OXFORDSHIRE COUNTY COUNCIL'S RESPONSE TO CONSULTATION ON THE FOLLOWING DEVELOPMENT PROPOSAL

Application no: 22/00747/OUT

Proposal: Outline planning application for the development of up to 370 homes, public open space (including play areas and woodland planting), sports pitches and pavilion, drainage and engineering works, with all matters reserved (appearance, landscaping, layout and scale) except for vehicular and emergency accesses to Bicester Road.

Transport Schedule

Status		Status Date
Information		Feb 2022
Drawn	Checked	Date
HG	AE	22.02.22
Scale	Number	Rev
As shown	10669-SK-05	F
0 10 20 30 40 50		
METRES

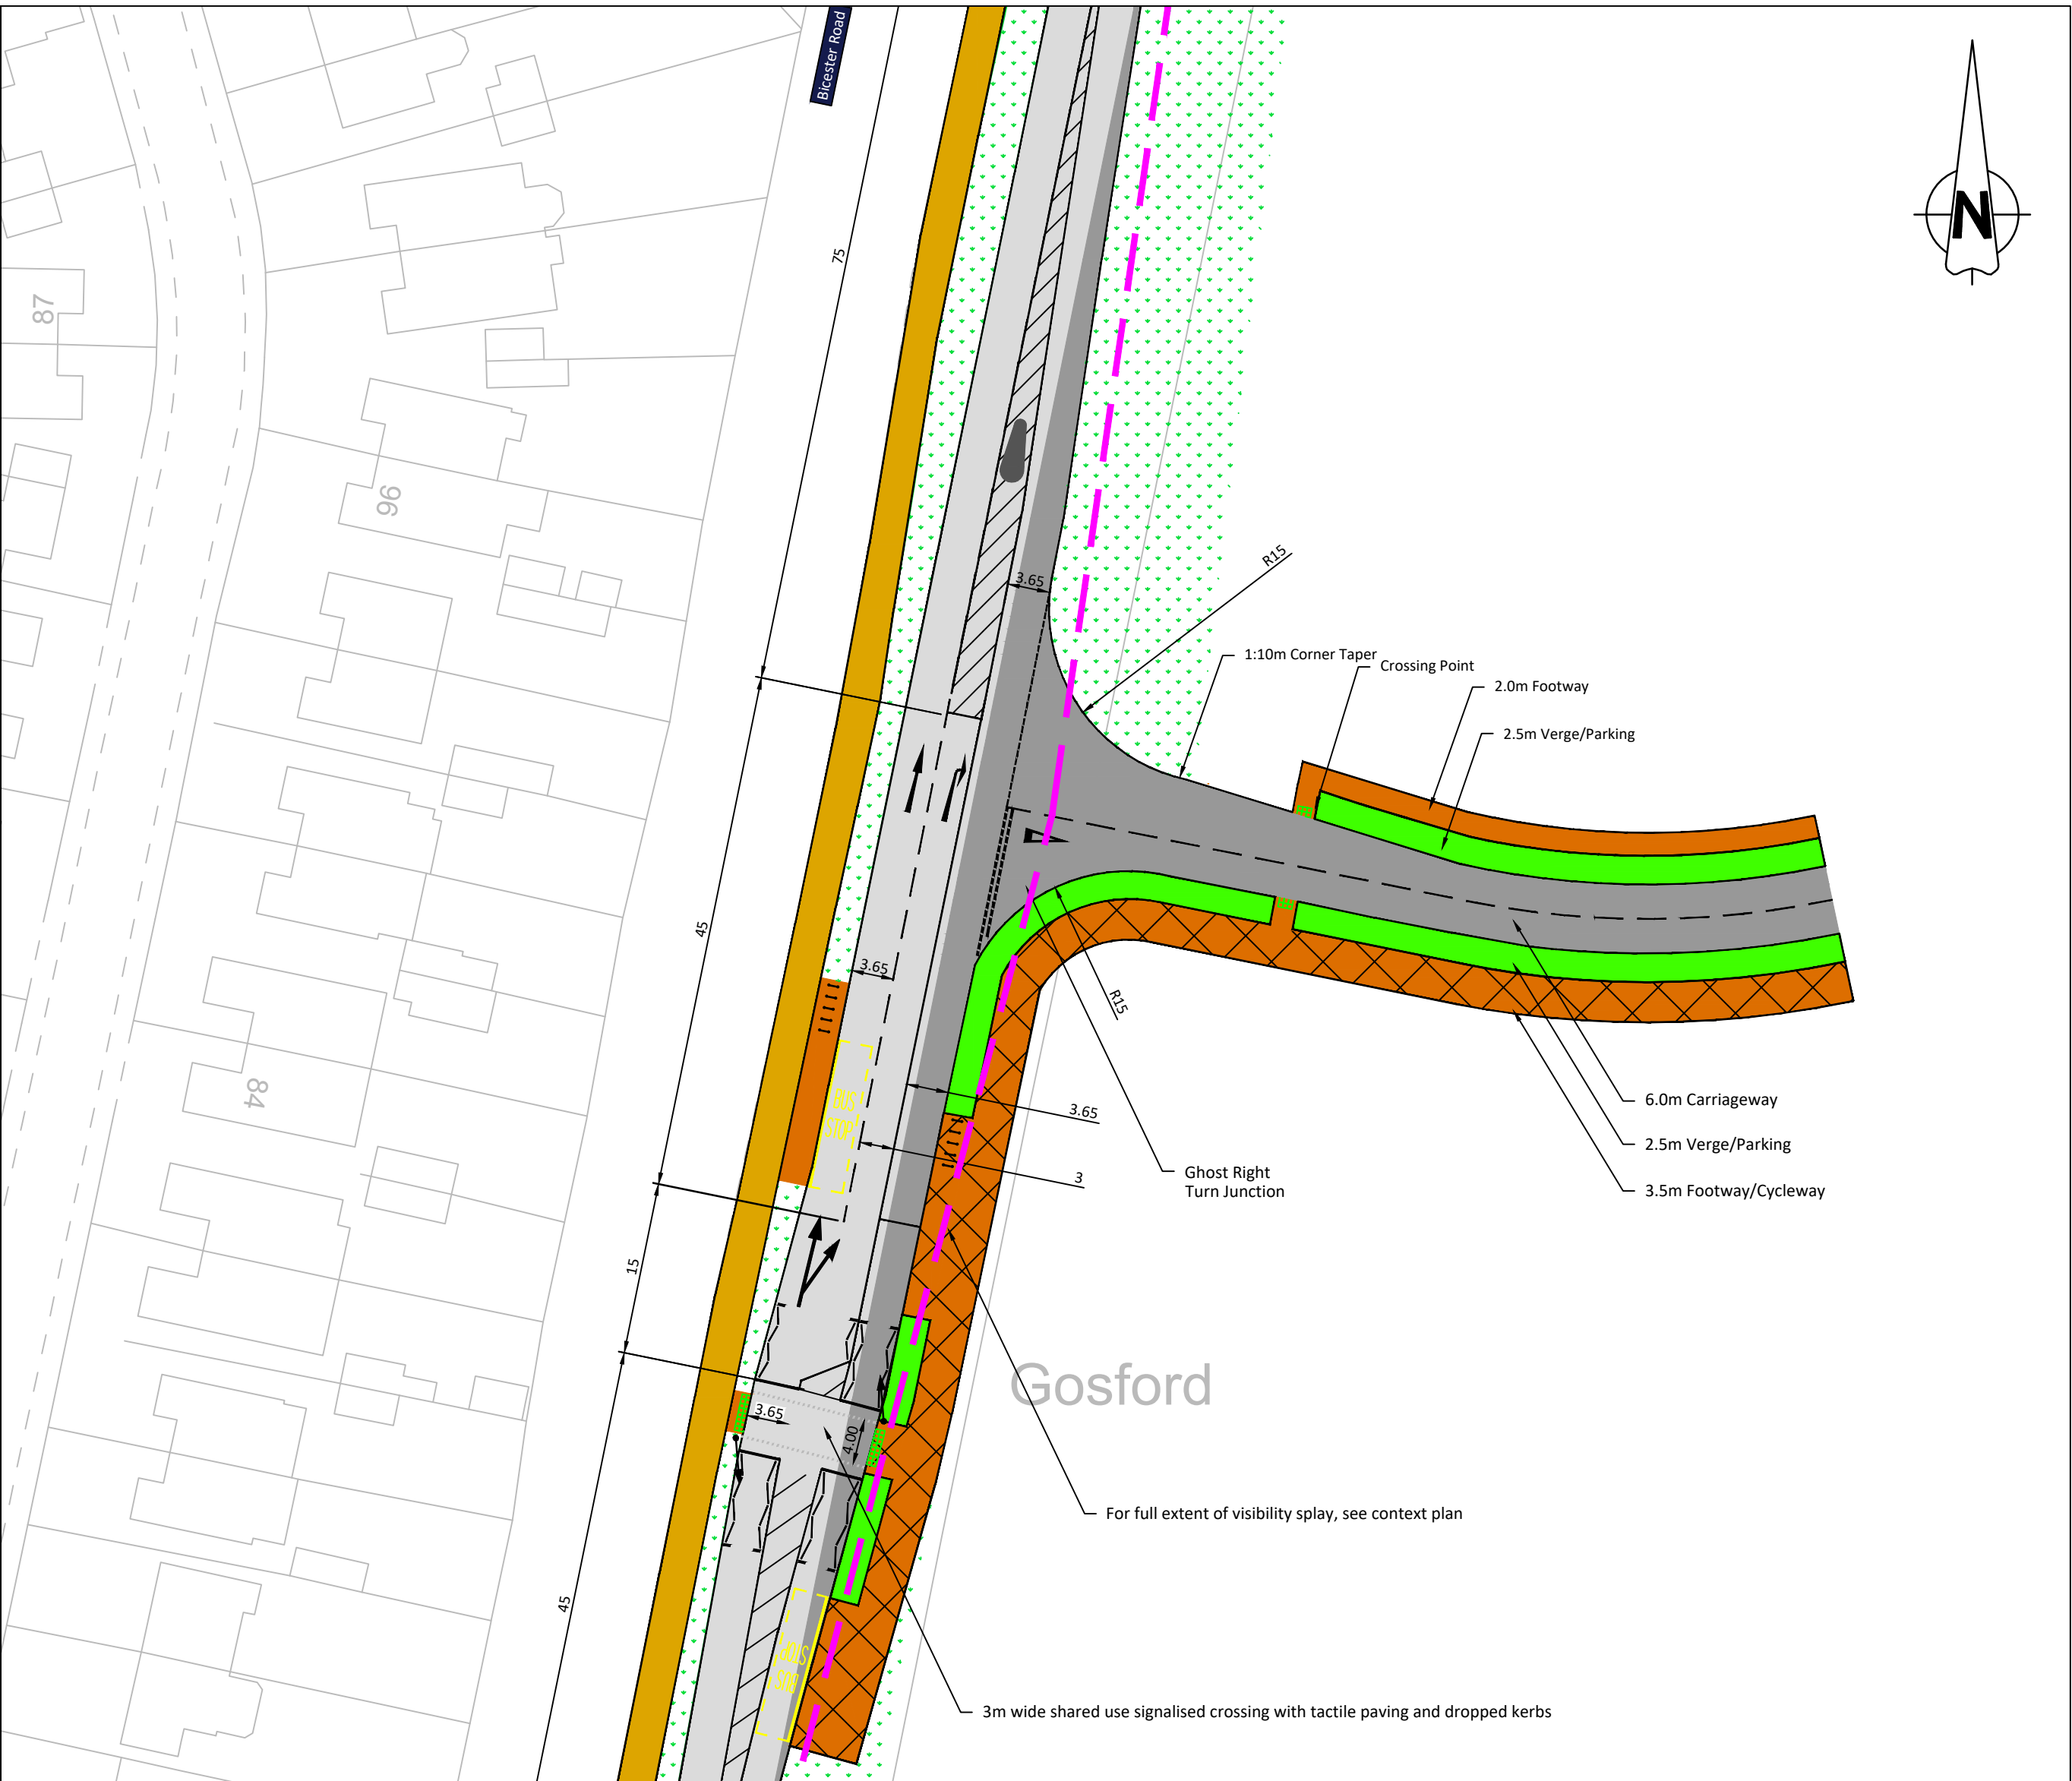
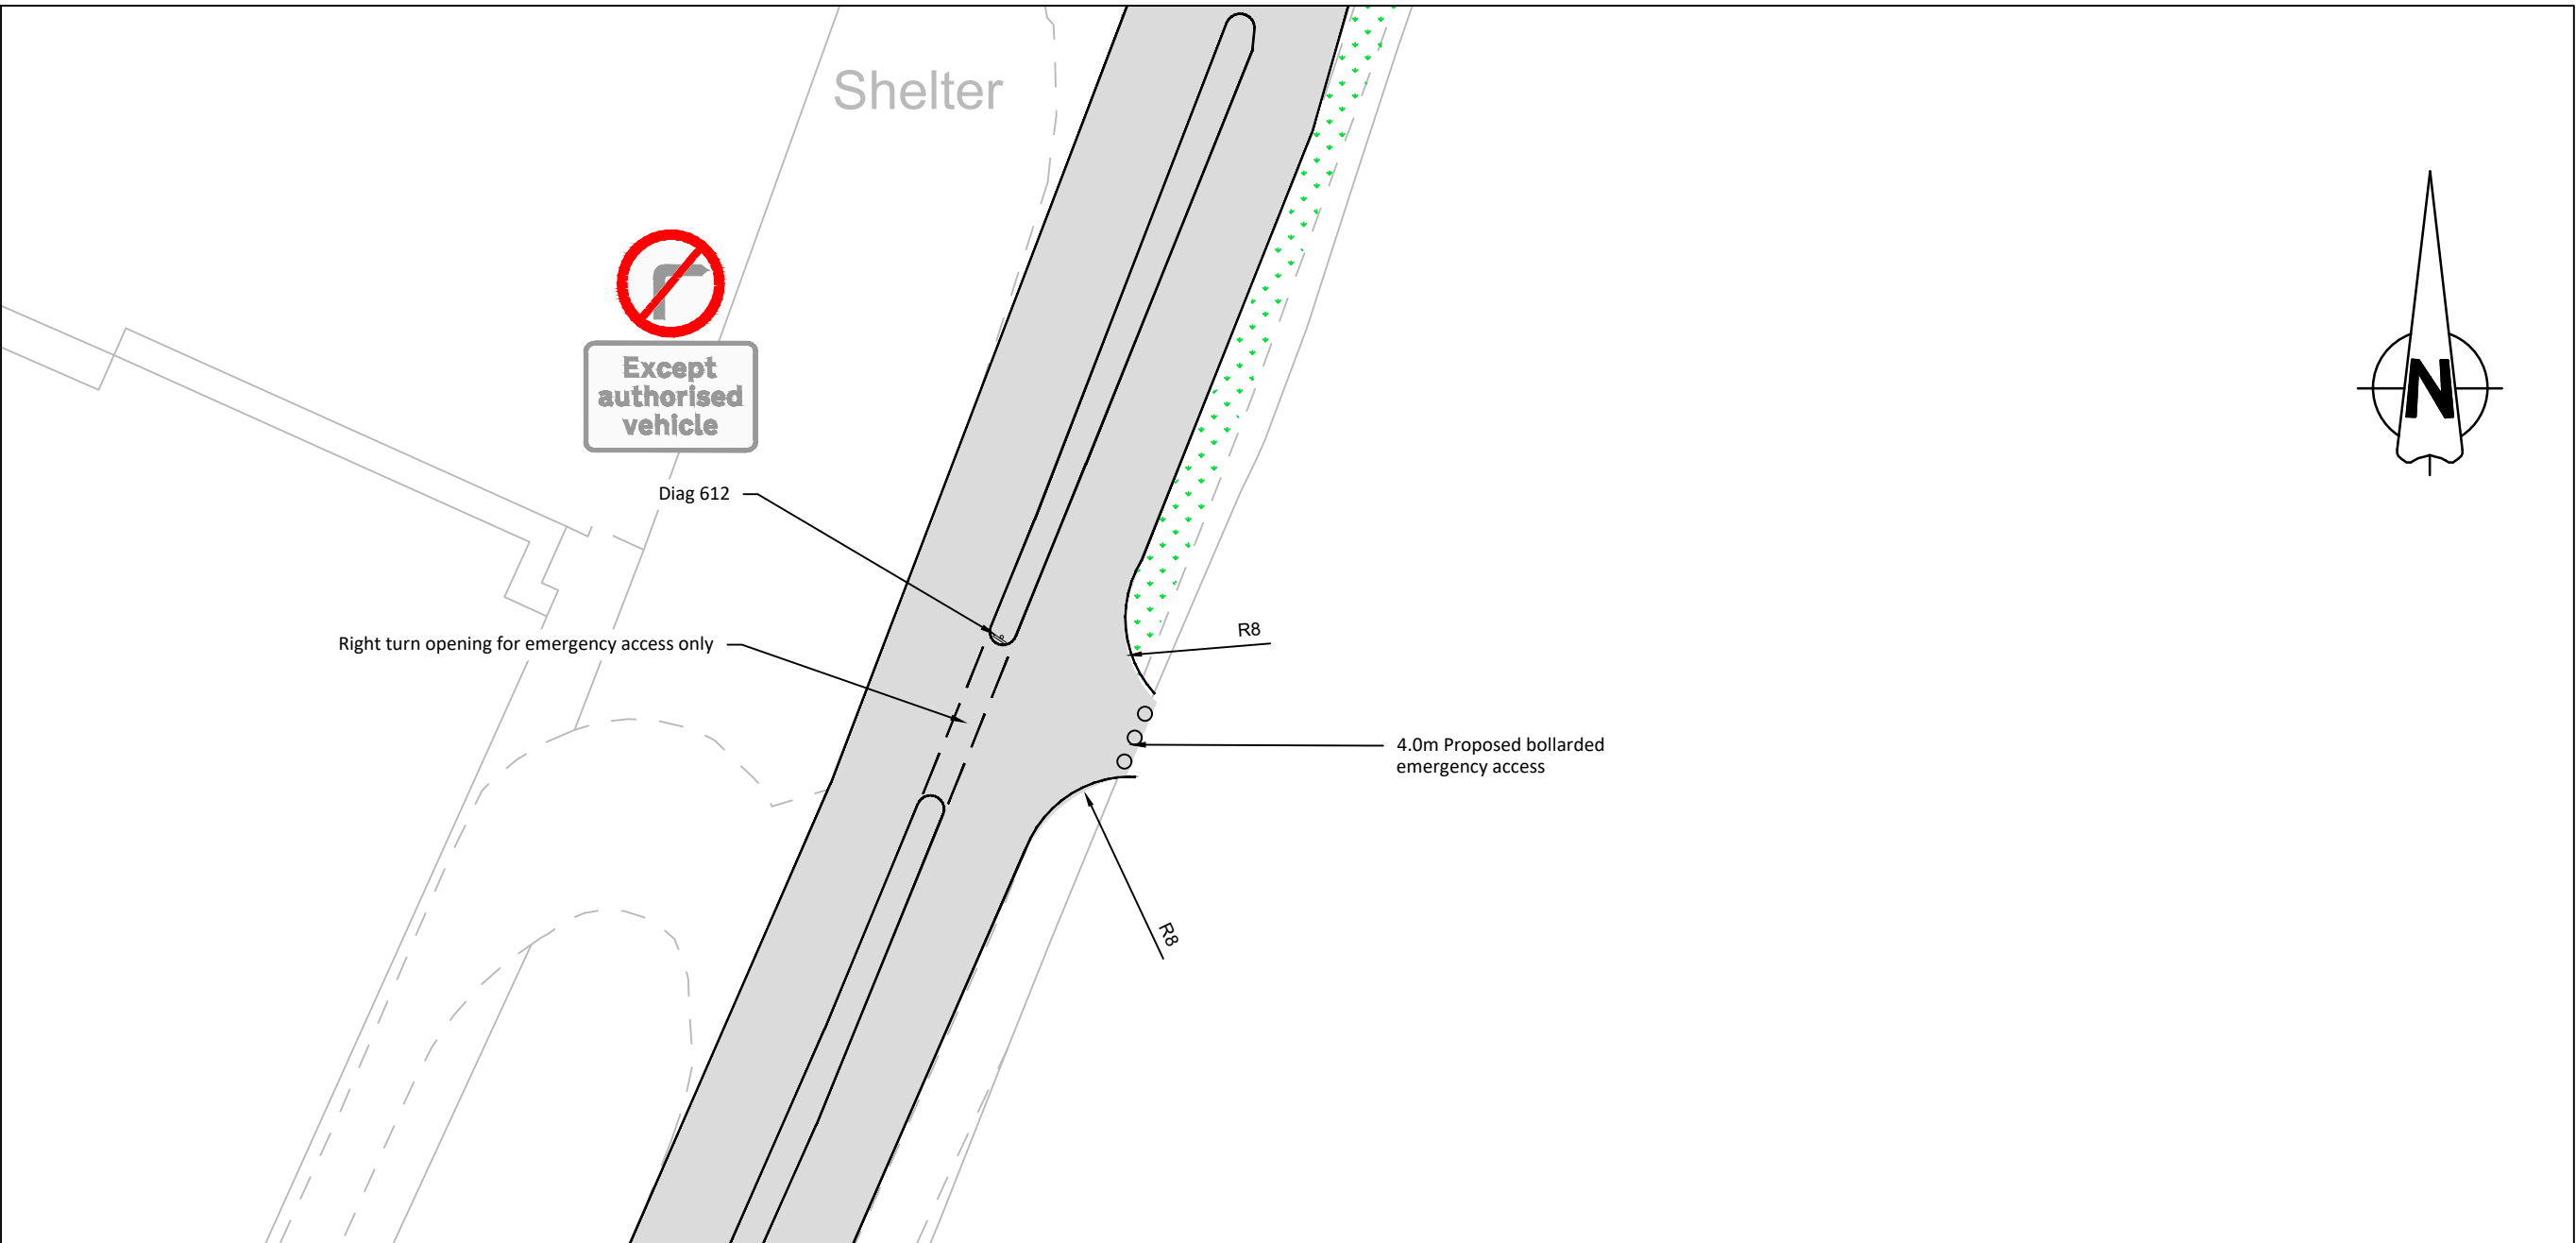
In our previous report, I noted through the submitted tracking drawings that the access geometry could not safely accommodate large vehicles without infringing into oncoming traffic particularly for the right turning lane. While the width of the access road has been increased to about 6m wide for the first 10metres, this has not improved the prevailing concern of affected incoming vehicles rather than the left turning vehicles. The tracking exercise on the revised junction still presents the same conflict between right turning arrivals and left turning exiting traffic.

This conflict may be overcome by shifting the centre line of the access carriageway to provide a wider turning angle/ envelope for the left turning stream than the arrival lane as illustrated above.

No development shall commence unless and until revised details of the means of access between the land and the highway, including, position and layout have been submitted to and approved in writing by the Local Planning Authority. The means of access shall be constructed in strict accordance with the approved details and shall be retained and maintained as such thereafter.
